Ref: Planning Application 3/2023/0488

4A & 6A Back York St, Clitheroe

Proposed Floor Plans 1:100 @ A3

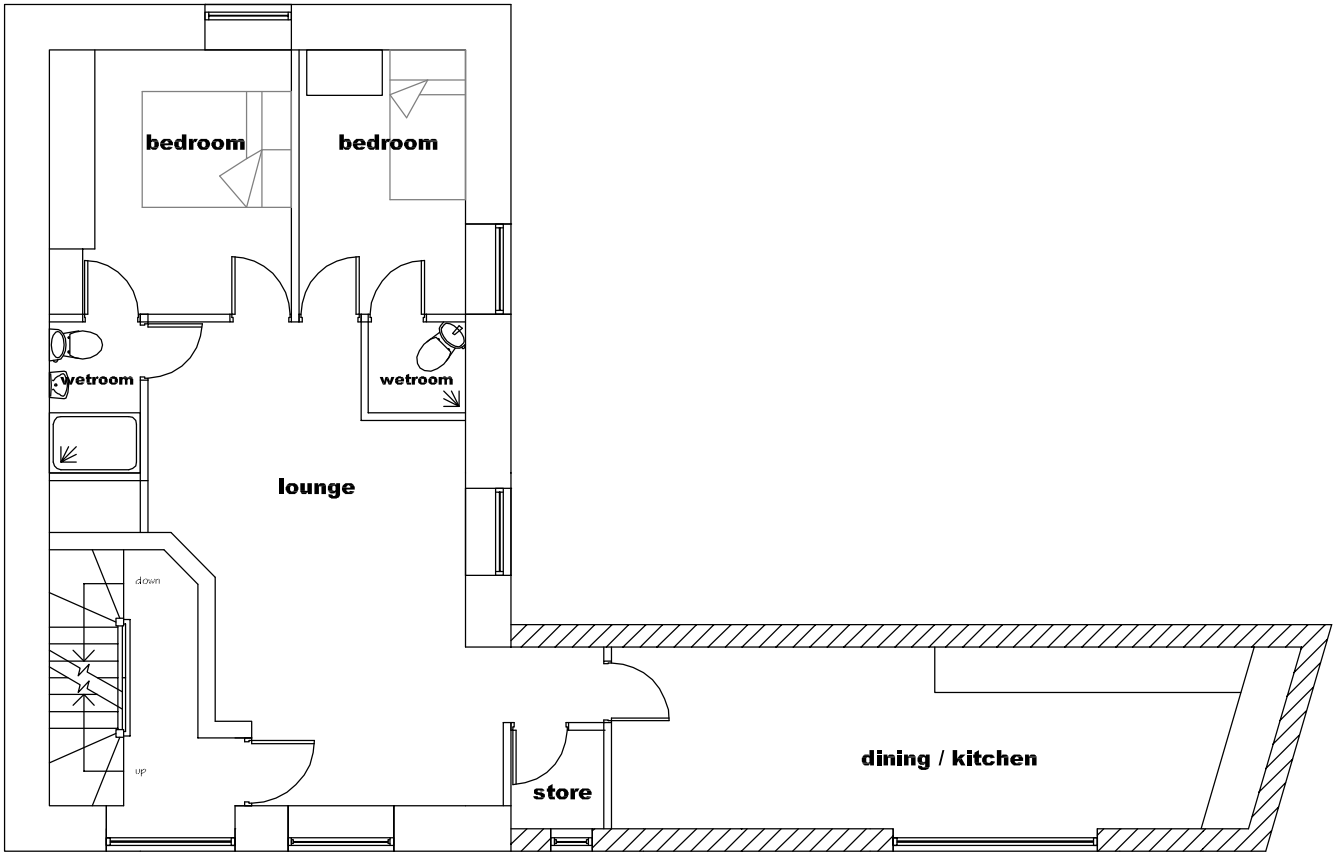
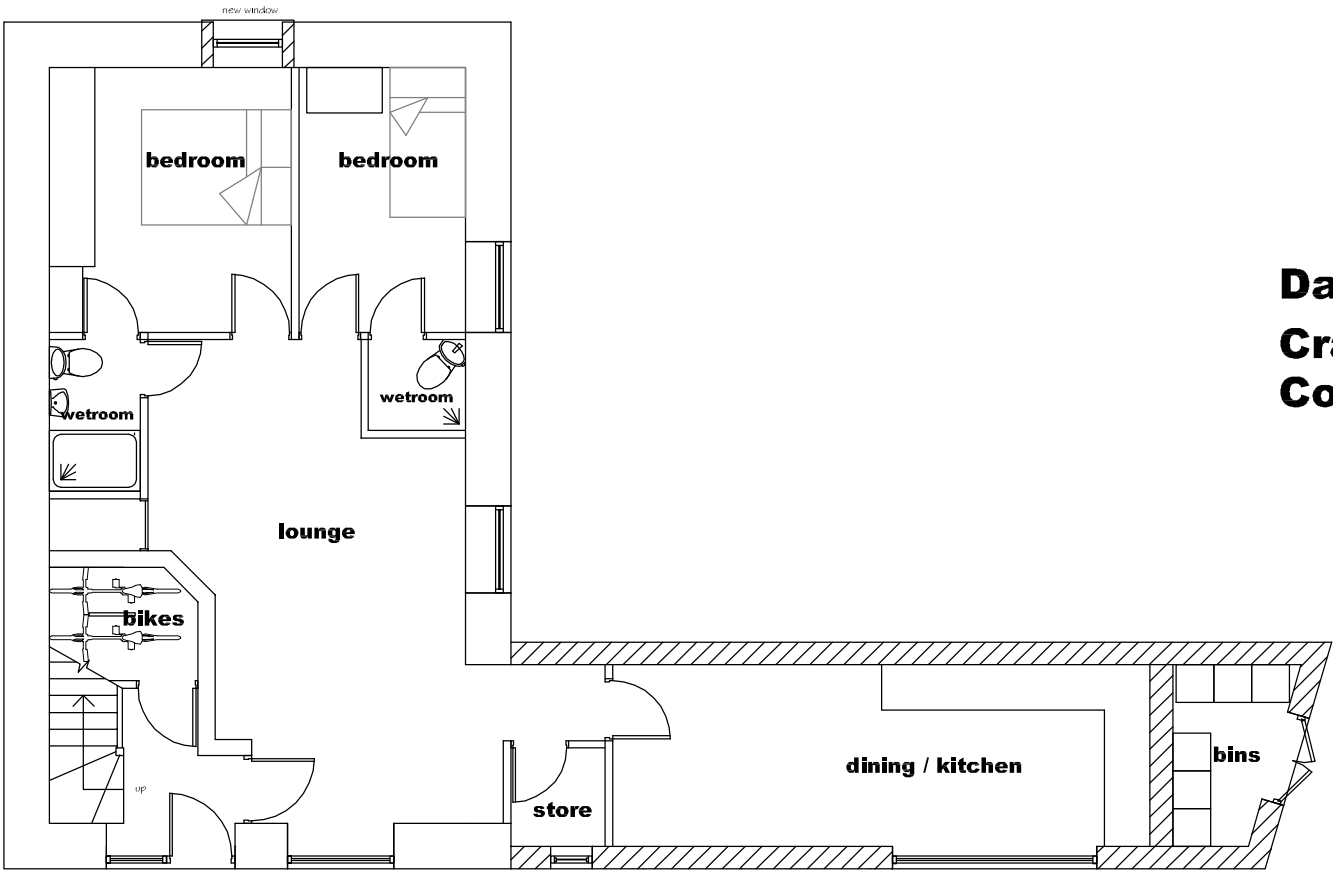
The proposed site plan is inaccurate. The current minimum distance between the proposal & [REDACTED]. The proposed plan shows it as around [REDACTED]. This would make access to [REDACTED] which are used daily [REDACTED] impossible. If the corner of the new building could be rounded/chamfered to retain the existing 2.5 metres then I would withdraw this objection.

1. I read that the new foundations will be piled. Bearing in mind that [REDACTED] is on its original foundations, what responsibility does the developer have for any damage to [REDACTED] resulting from his piling operation?
2. The extension to the full length of the building on the second floor will cause considerable loss of light, putting [REDACTED] & reducing the opportunity [REDACTED]
3. Would access be required to [REDACTED] & the proposal? If so, I assume this would need [REDACTED] as it would almost certainly damage [REDACTED] & also [REDACTED] parking. To date I have had no contact regarding this but, in the event, I would certainly need some guarantee.
